DECISION DELEGATED TO HEAD OF PLANNING

Application No: H16-0717-22 **Applicant:** M J L Welding & Fabrication Ltd.

Proposal: Creation of 3 self-contained apartments on the first and second floor. Works of repair, restoration and replacement of internal and external features and materials

Location: 14 Market Place Spalding

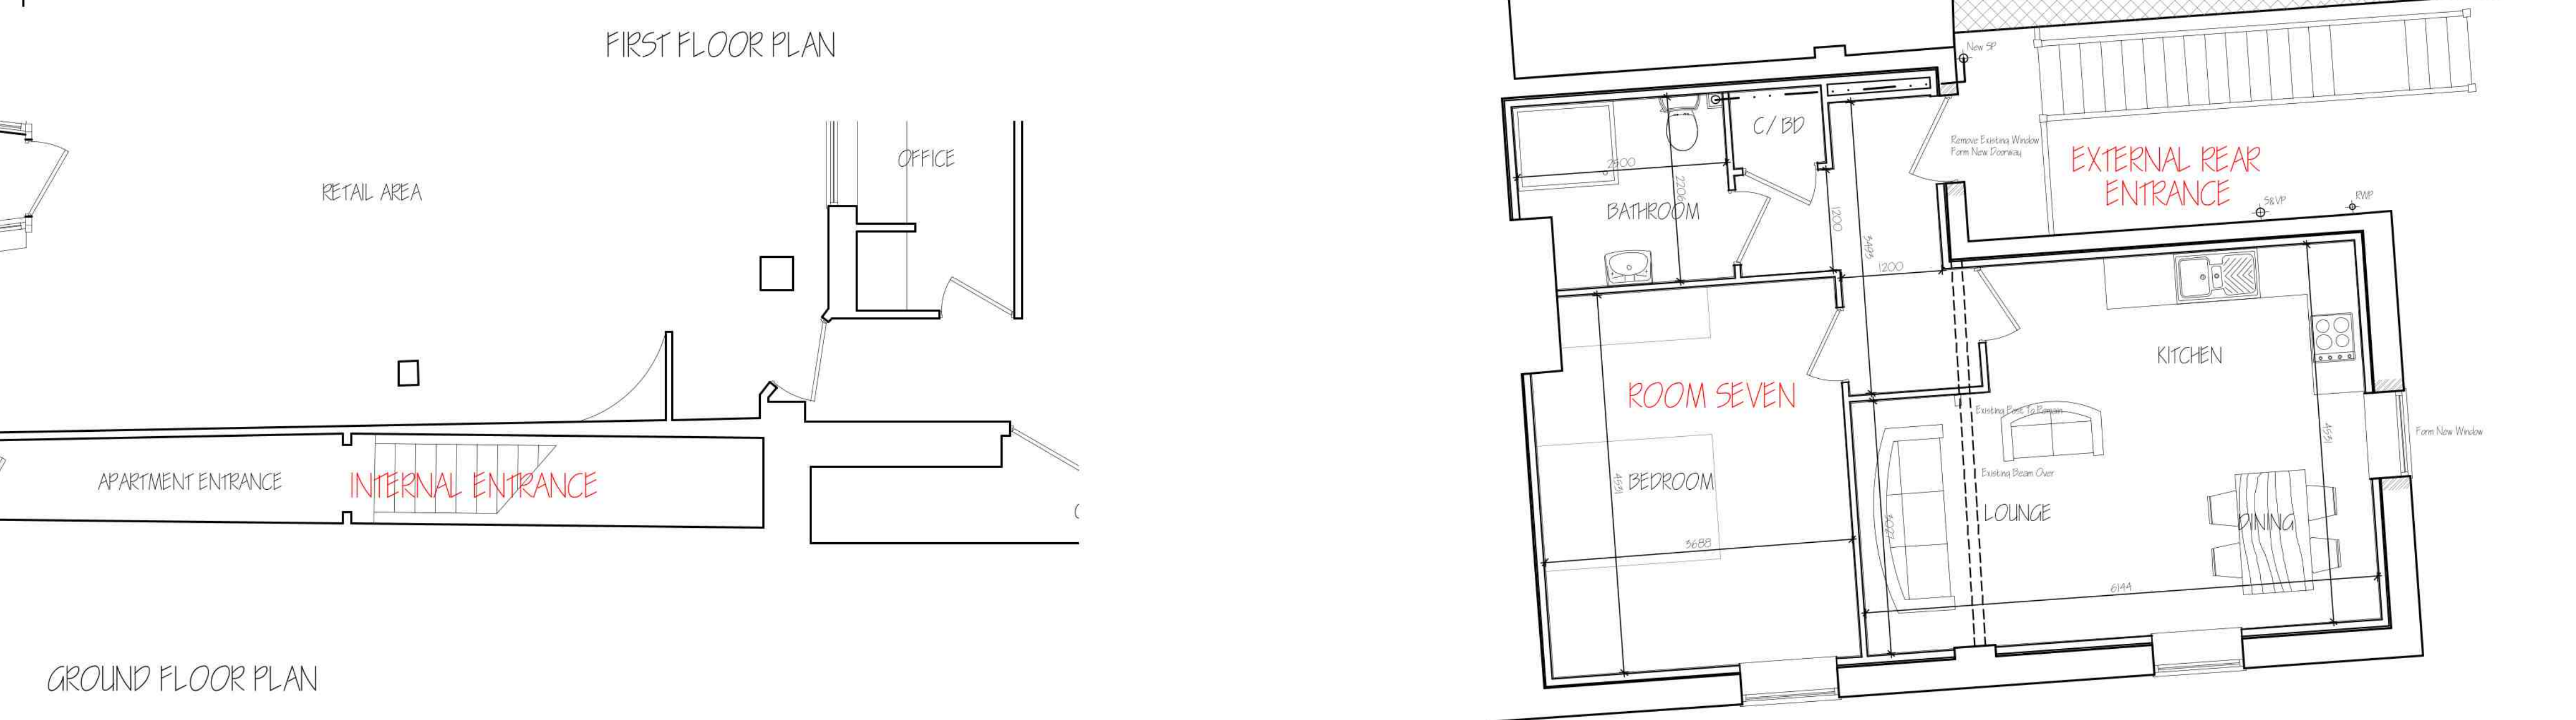
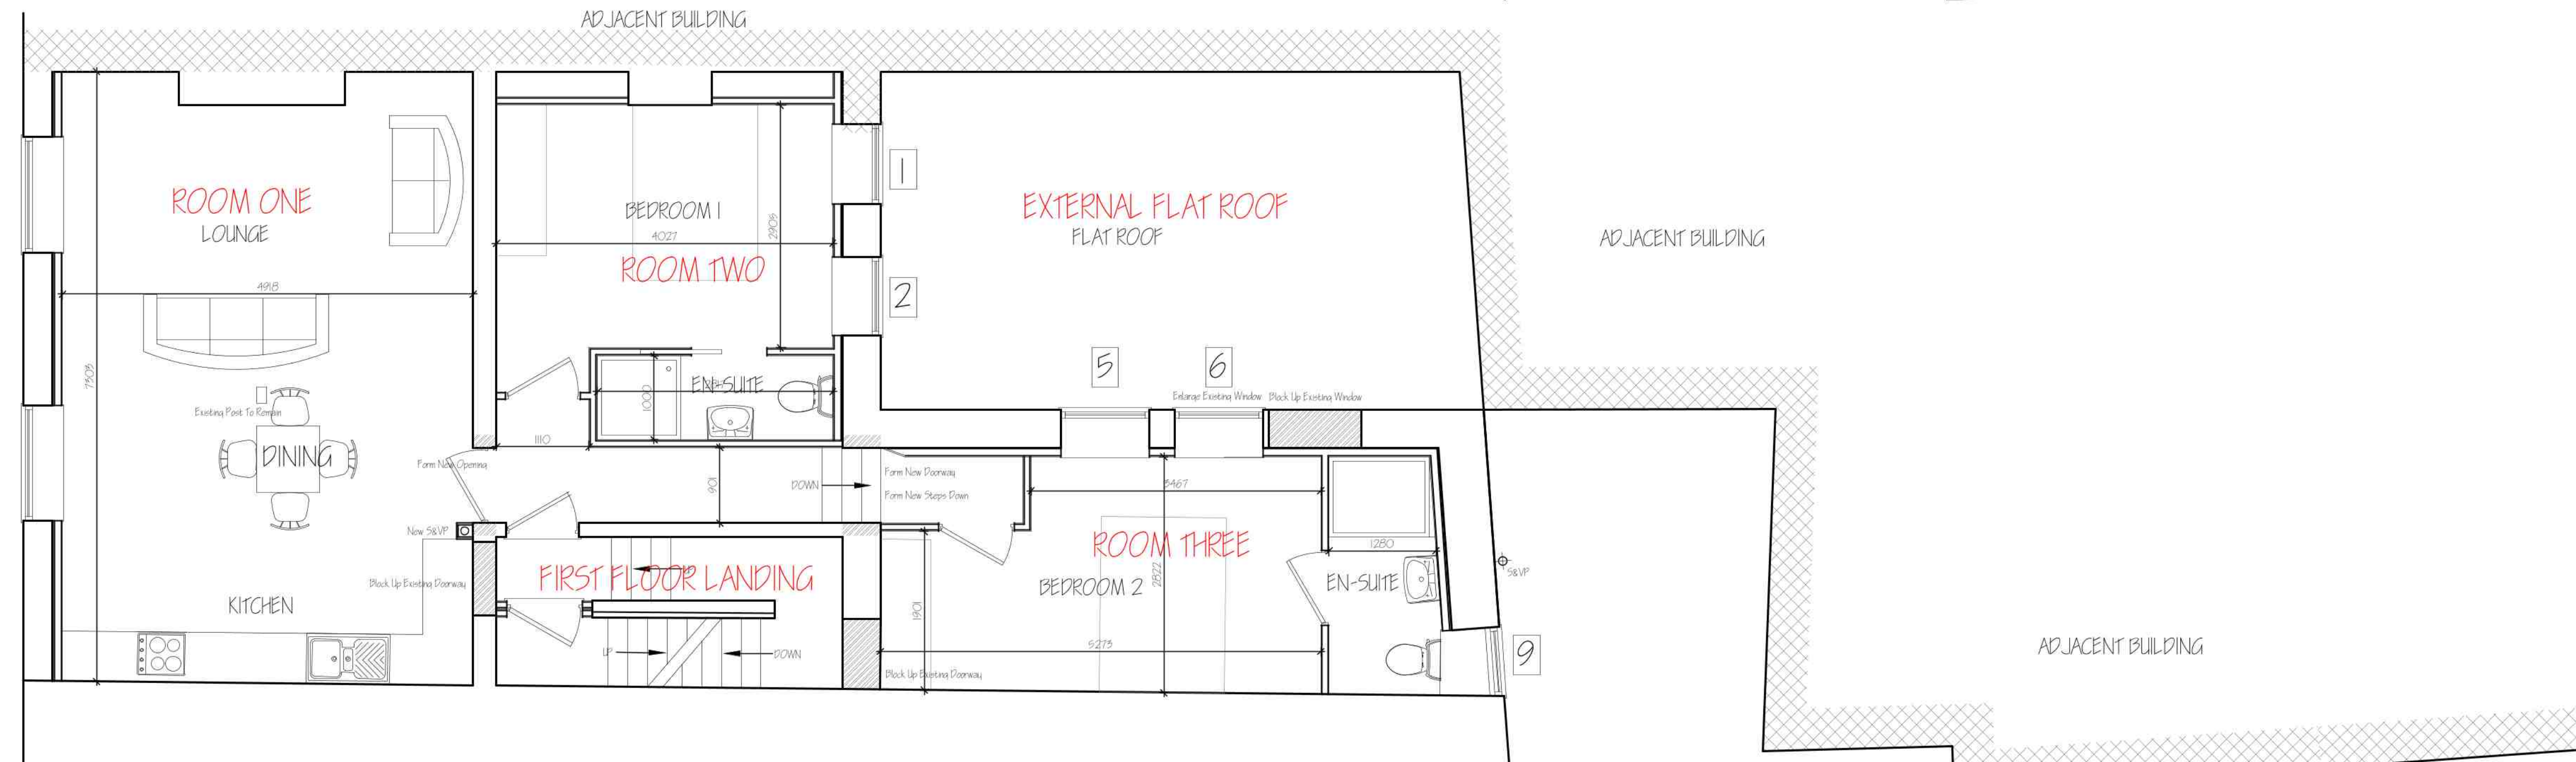
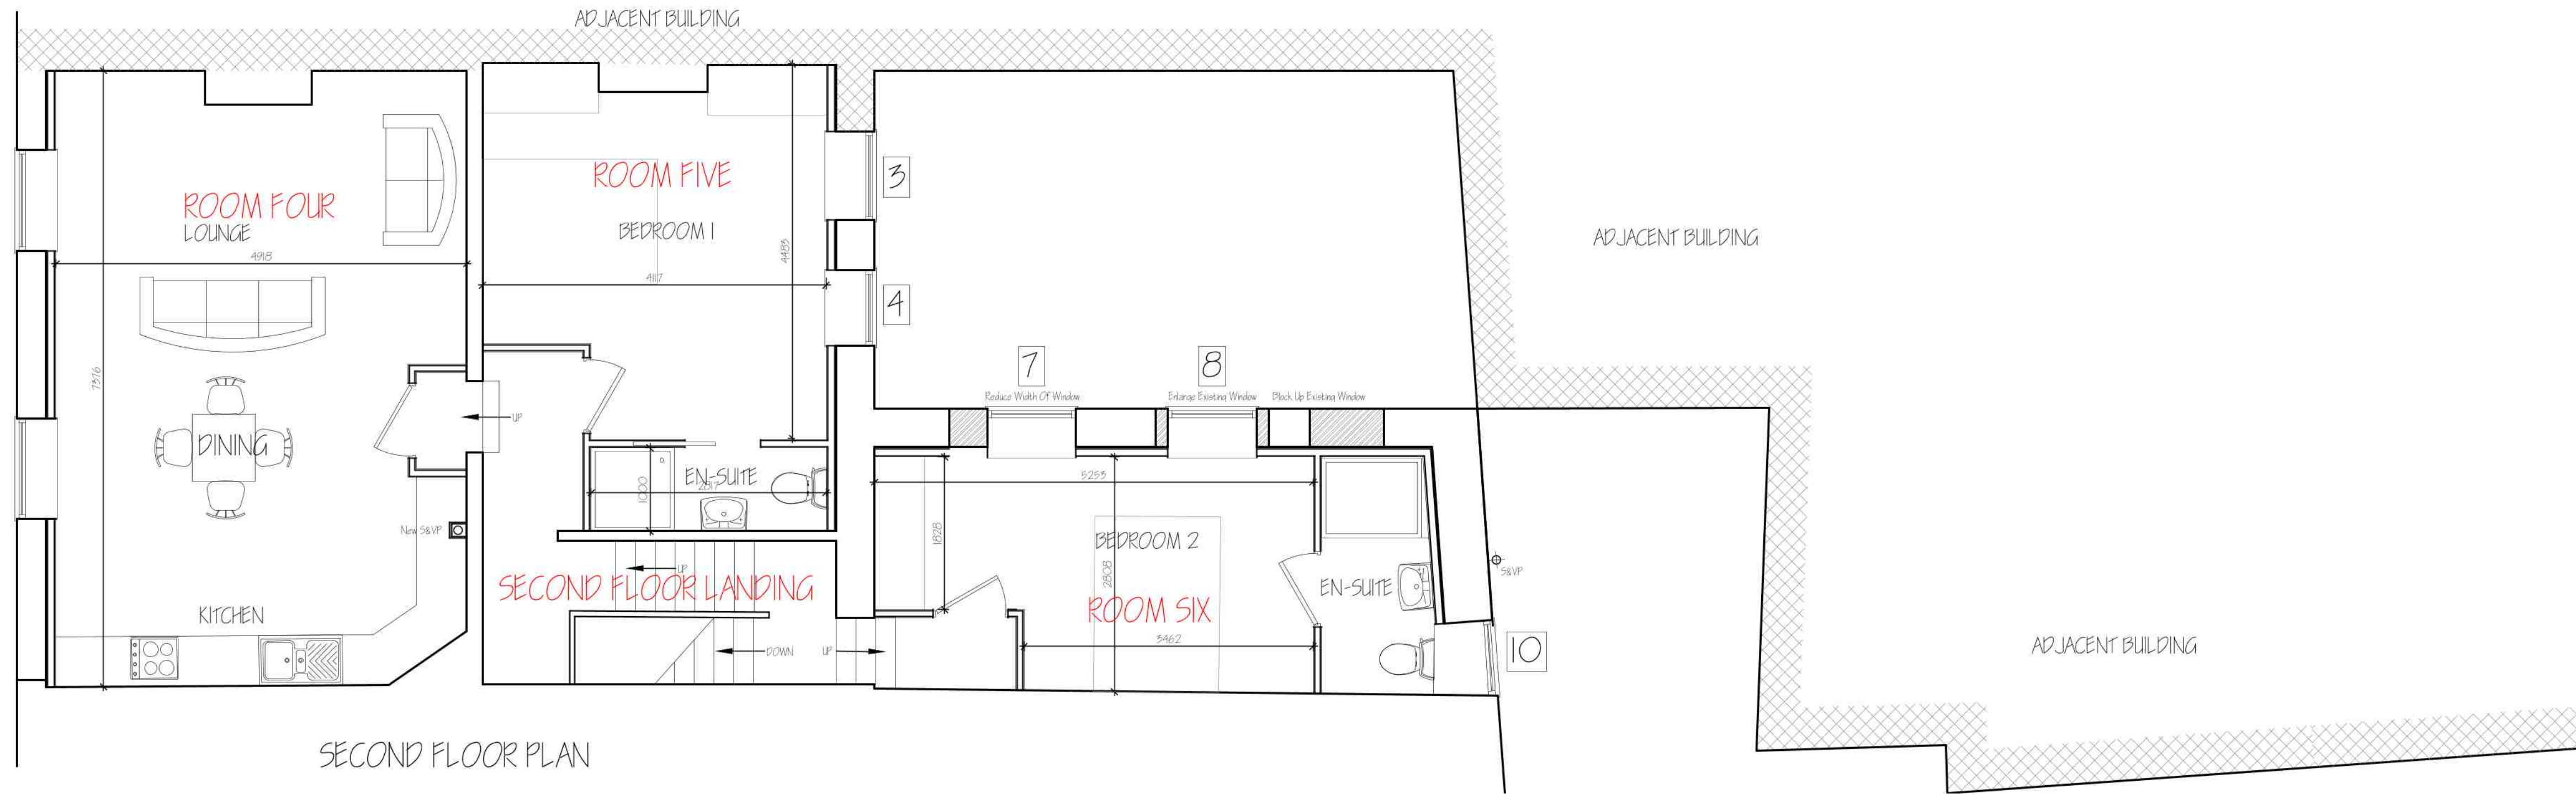
We also note the proposals to block the left hand rear windows. Whilst it is clear that there has been internal alteration, we would hope that the applicant will seek to incorporate any original window openings into the design where these have now become apparent as part of the works being undertaken. We urge that all rear windows are to a design as near as possible to that would have been the case when the building was originally built. Some of the windows are clearly much more recent additions and appear out of keeping with others in the building. Considered replacement using traditional materials to designs sympathetic with the age of the building would most likely be the best outcome for the building.

Following the submission of the latest document intended to justify the proposal to install UPVC windows to the rear elevation of this listed building, I write to confirm that I am satisfied with the justification provided and therefore wish to raise no objection to the principle of their installation on the rear elevation of this property.

It should, however, be made clear that under normal circumstances, such a proposal would be absolutely unacceptable and that it is only due to access difficulties and land ownership arrangements that are totally unique to this specific site that it can, in this single instance, be justified in the interest of maintenance. It remains an expectation that all other windows and external accoutrements featured on the building should utilize traditional, heritage-appropriate materials.

I would also recommend that the applicant should be required to utilize high-quality wood-effect UPVC windows and that to ensure that this is the case, should the application be approved, it be accompanied with Condition MD13, requiring the submission and approval in writing of details of external windows prior to installation.

In accordance with the response of the Conservation Officer, it is recommended that the applicant should be required to utilise high-quality wood-effect UPVC windows and that to ensure that this is the case, should the application be approved, it be accompanied with Condition MD13, requiring the submission and approval in writing of details of external windows prior to installation.
